## Re: Final review of Plat for PB approved 31 Fore St (new 4 unit)

This project was approved by the PB on March 22 (approval letter attached) and they are now addressing the conditions of approval.

Re the Subdivision conditions, I would appreciate your review of the attached plat and condo docs (note that they will be submitting a stormwater main agreement too, later)

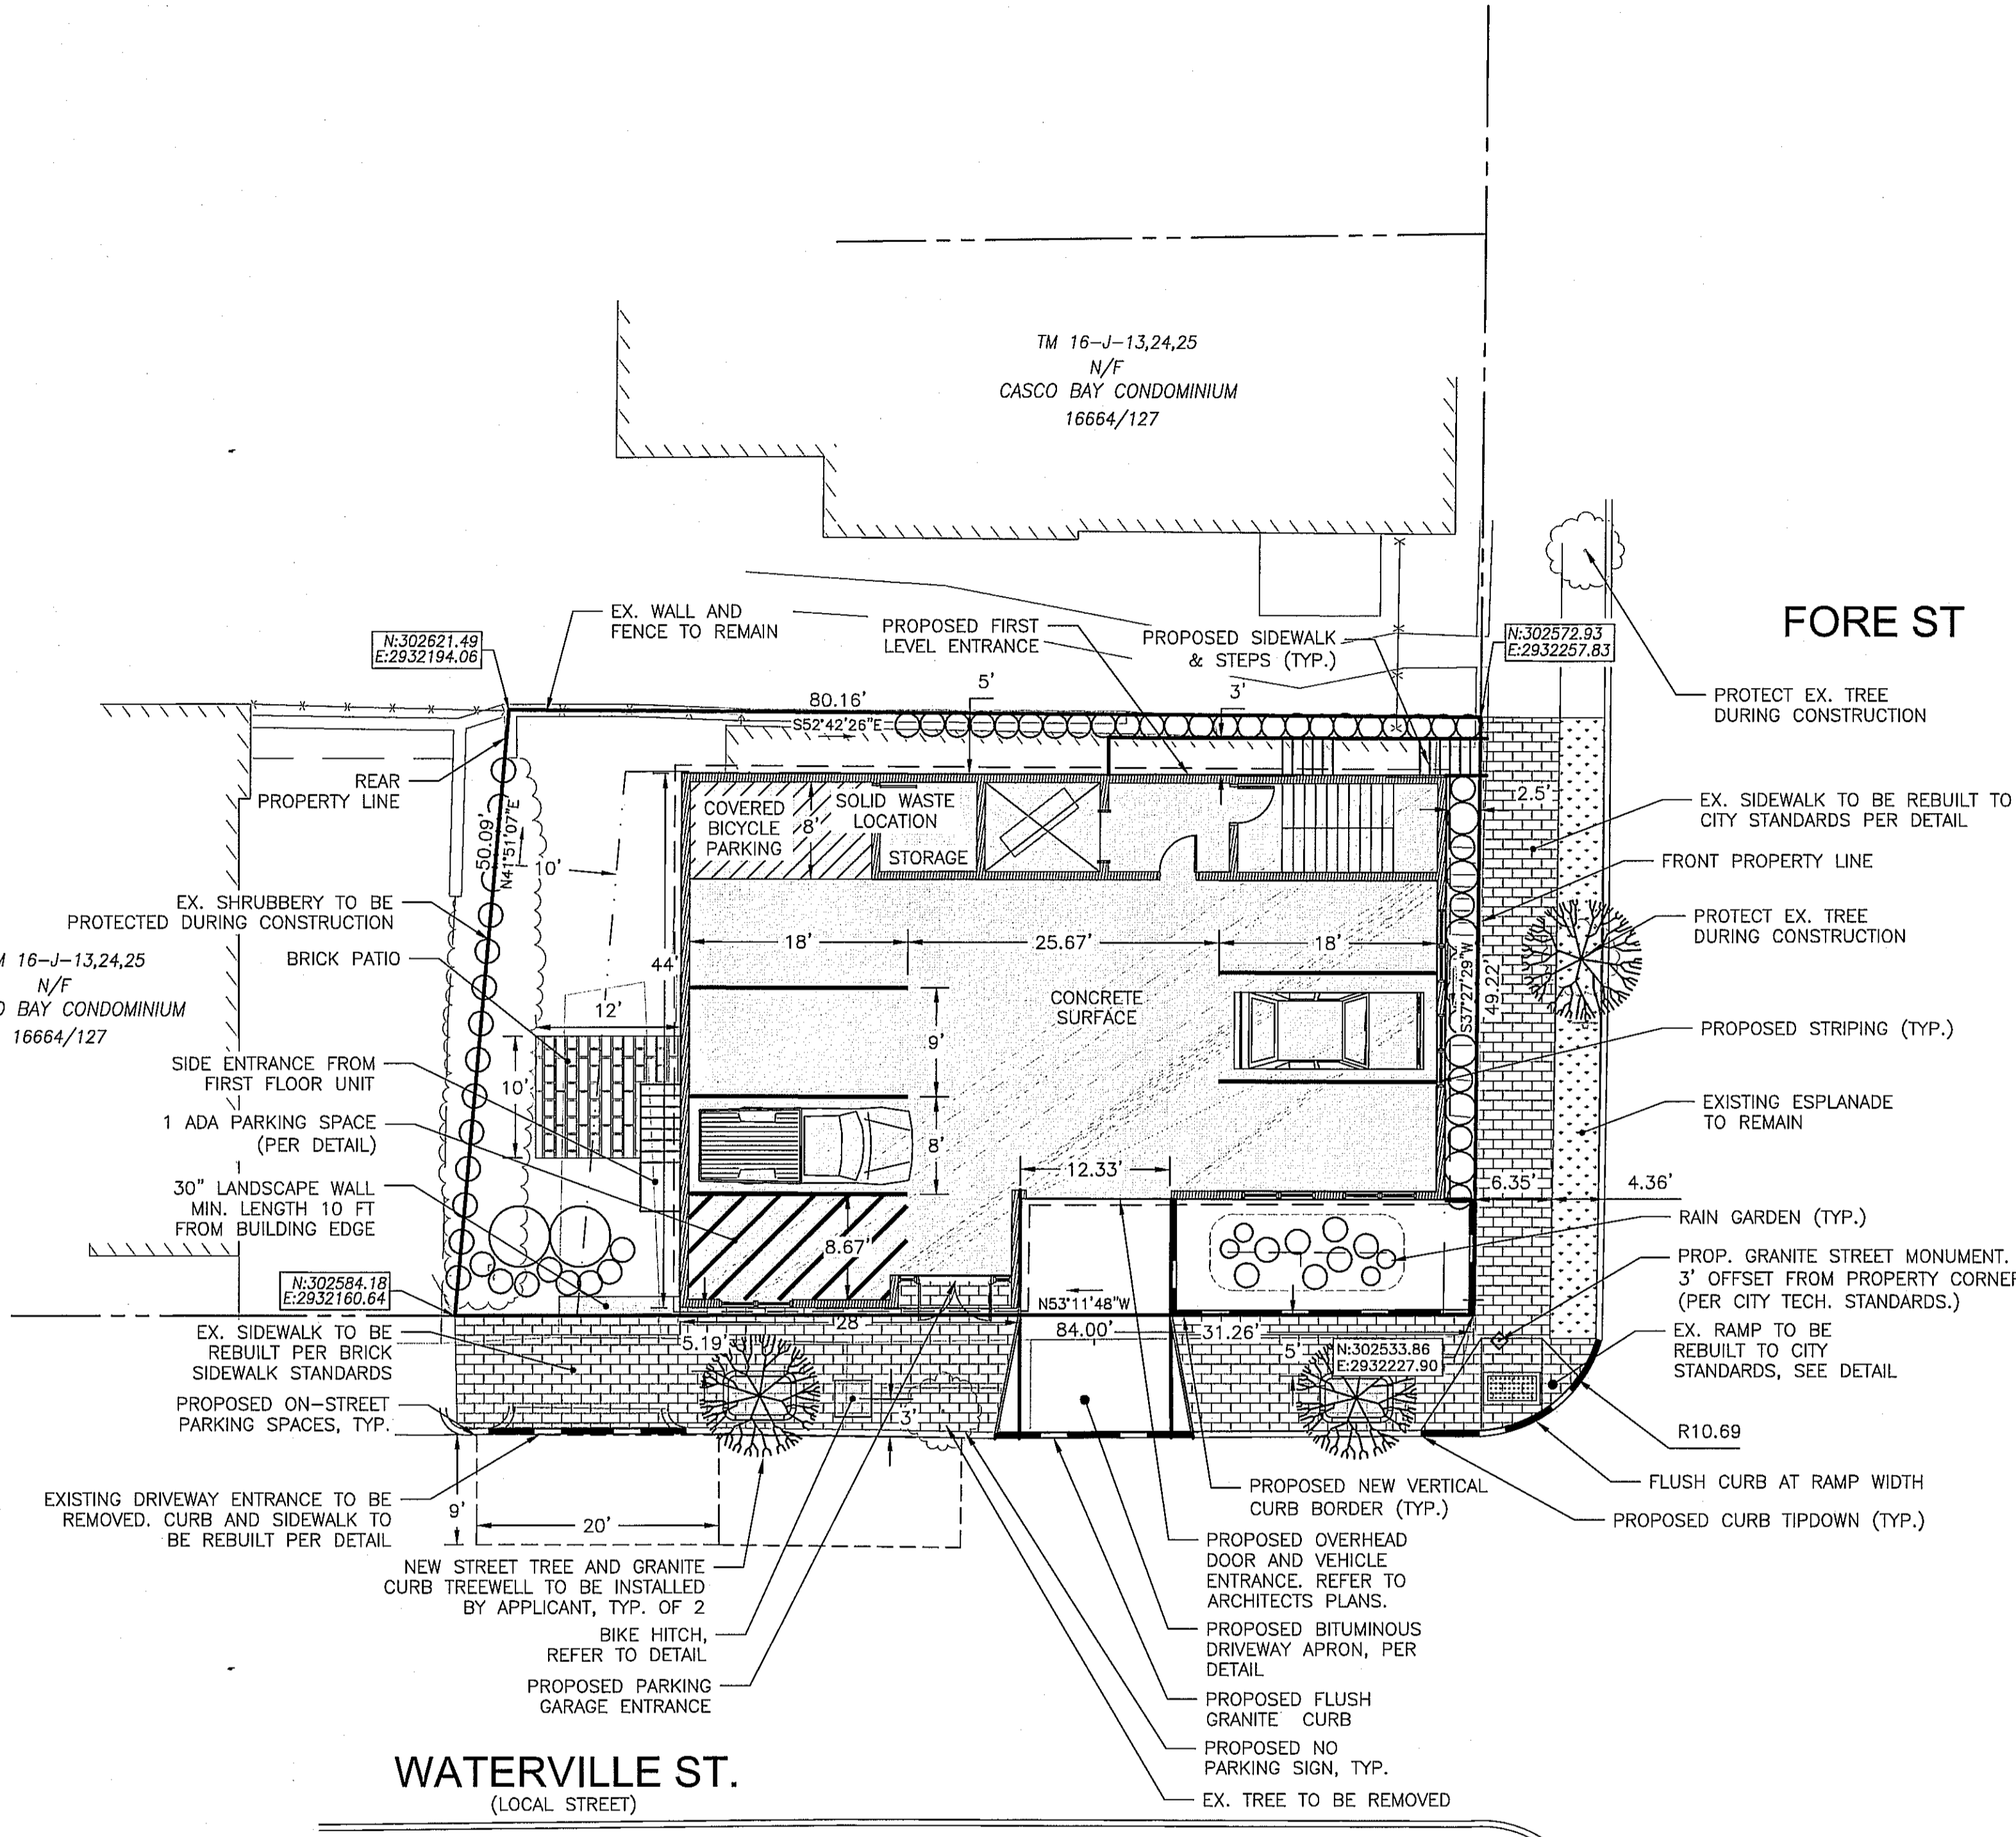
I think the plat looks good. The condo declaration is generally o.k. but I'm not finding an express reference to the requirement that the condo association be responsible for trash and snow removal, etc. with the specificity contained in the general note 12 (on the plat). The condo docs simply say that the association is responsible for maintaining the common areas. However, for the sake of clarity and being sure that the Board's intentions are carried out, I think it would be best if they specifically reference responsibility for each of the elements listed in that note.
